**Our Ref: W/10/11/
Your Ref:**

Please ask for:
Mrs S Honney-Bayes
01903 737500 Ext 37445
8th November 2011

Add dormer window to outbuilding (this application lies within the South Downs National Park Authority)

1 Watermeadow Cottages Waterworks Lane Warningcamp

AREA 55m x 55m A3
SCALE 1:200
CENTRE COORDINATES: 503631, 106652

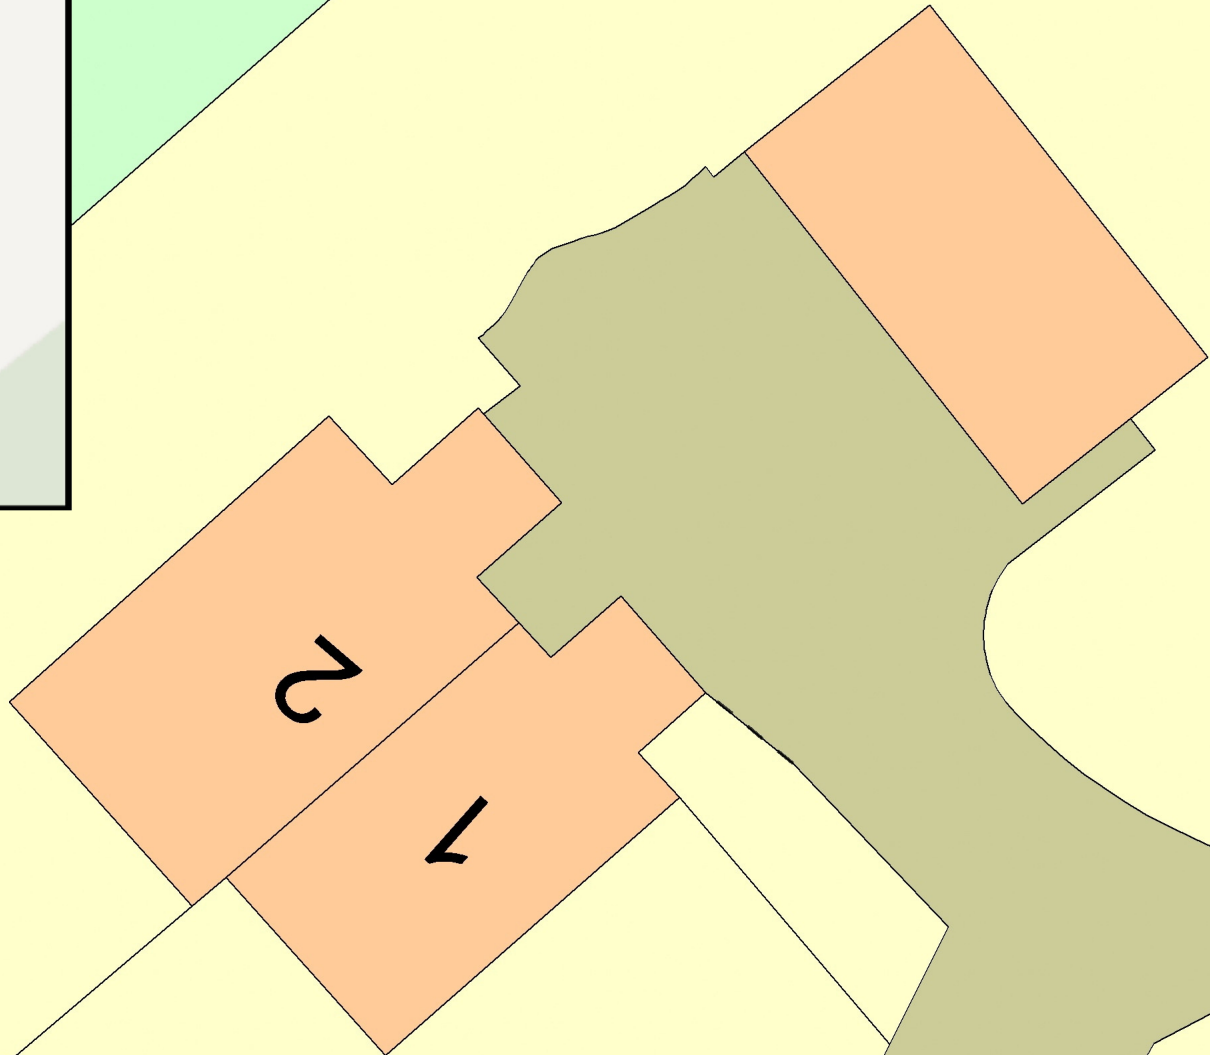
I require 1 electronic or 3 paper copies of a revised block/site plan at a scale of 1:500 (the plan provided is not to scale), showing the proposed works clearly highlighted and a north point, in accordance with the guidance notes available on our website detailed below (click on National List).

Ref: W/10/11/
(Existing)

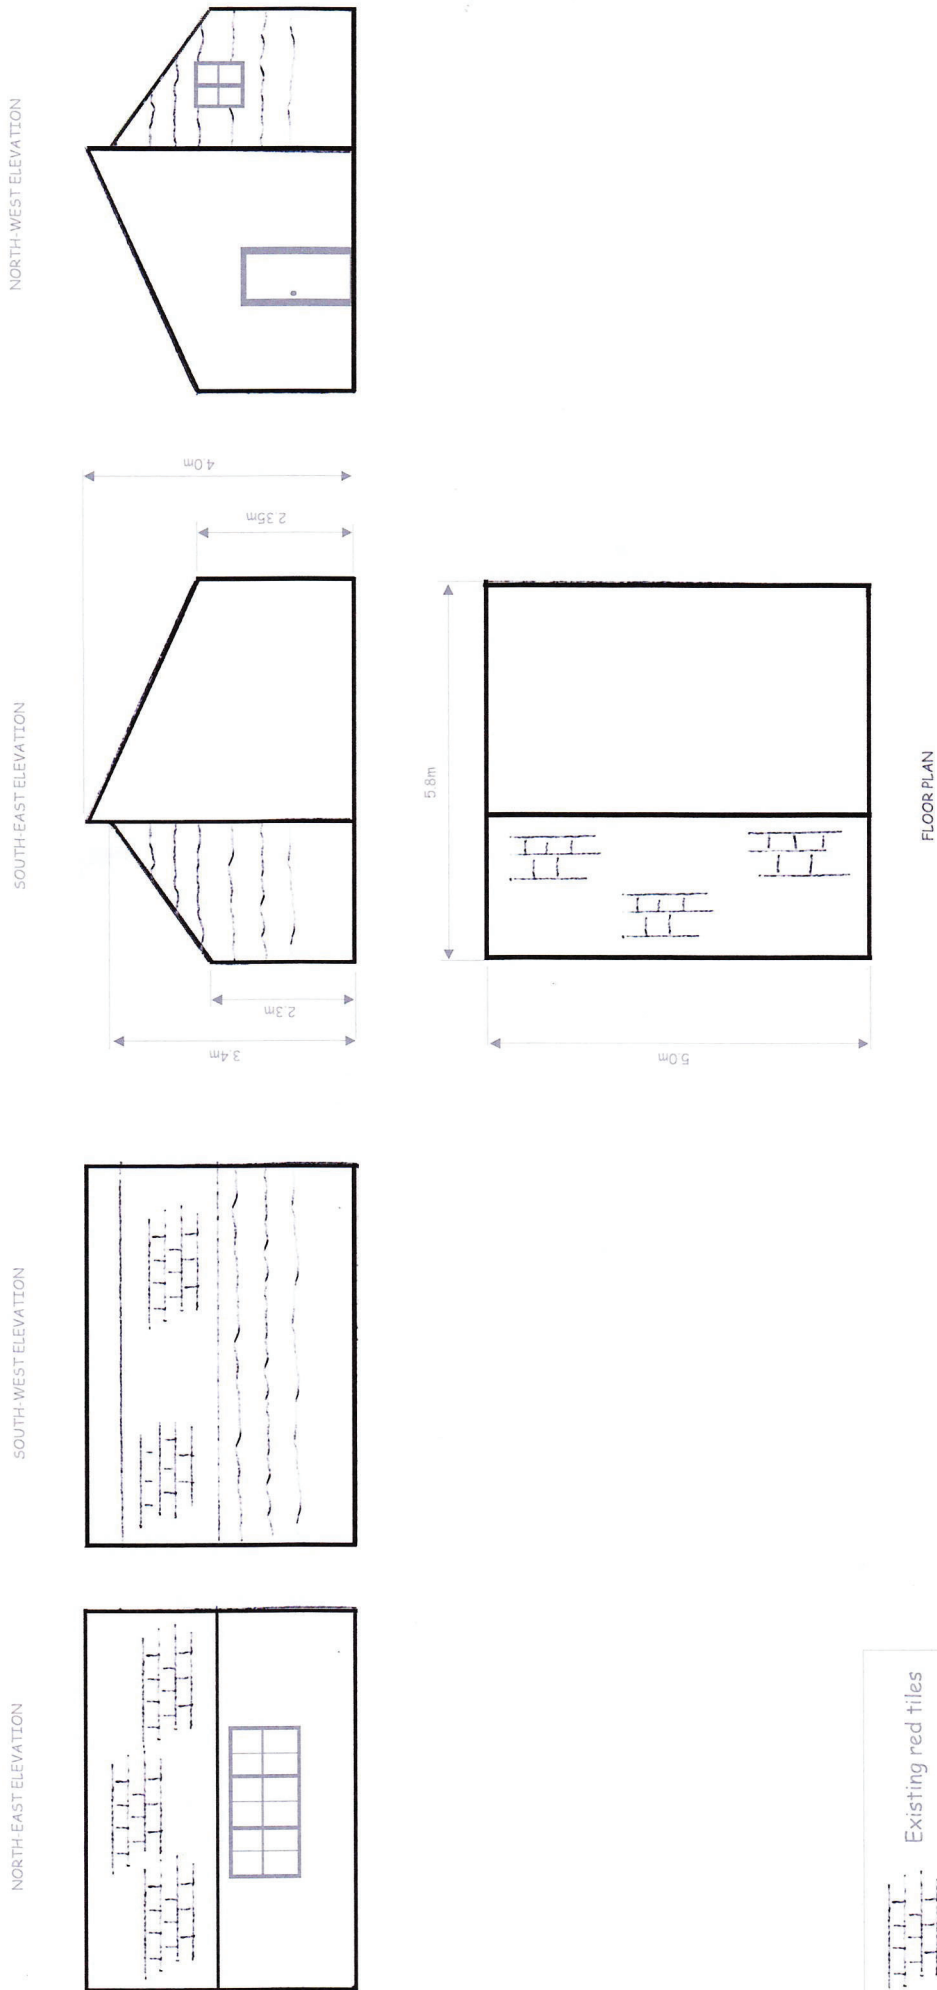
Please provide 1 electronic or 3 paper copies of existing and proposed elevations in accordance with the guidance notes available on our website detailed below (click on National List).

AREA 2 HA
SCALE: 1:1250
CENTRE COORDINATES: 503631 , 106652

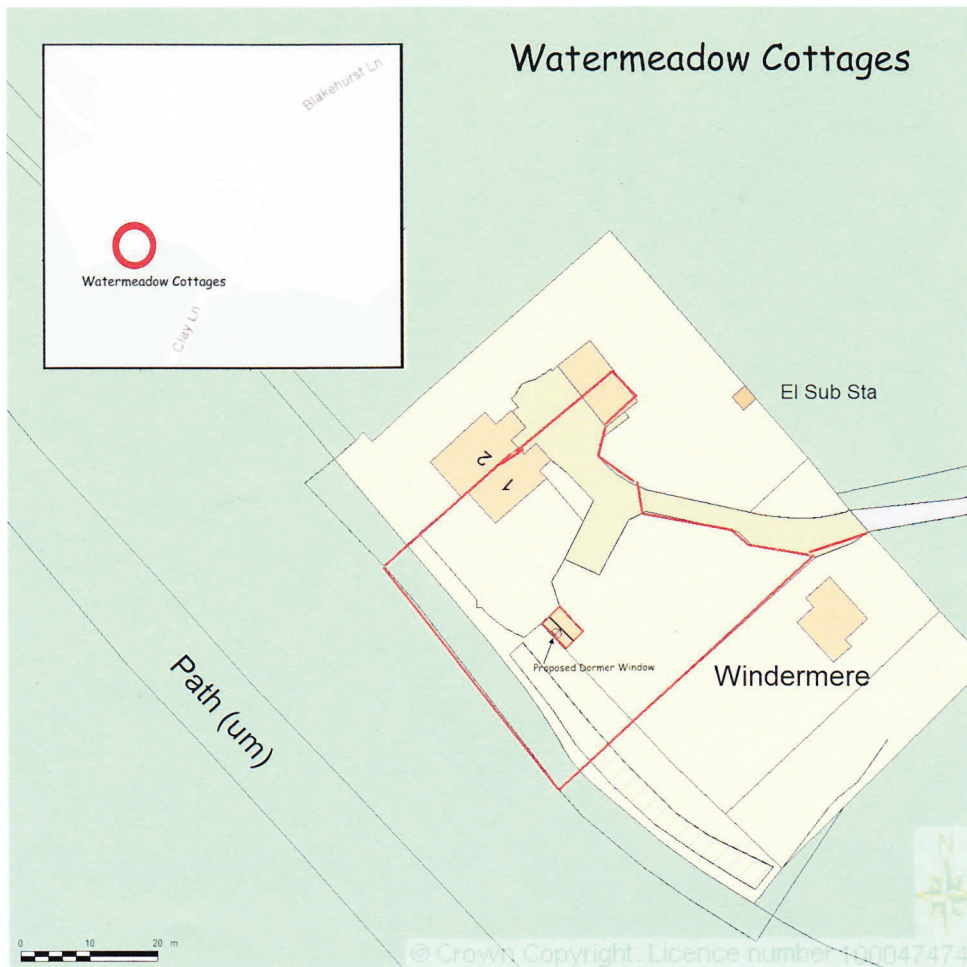
I require 1 electronic or 3 paper copies of a revised location plan at a scale of 1:1250 (the plan provided is not to scale), showing a red edge around the application site, at least 1 named road and a north point, in accordance with the guidance notes available on our website detailed below (click on National List).
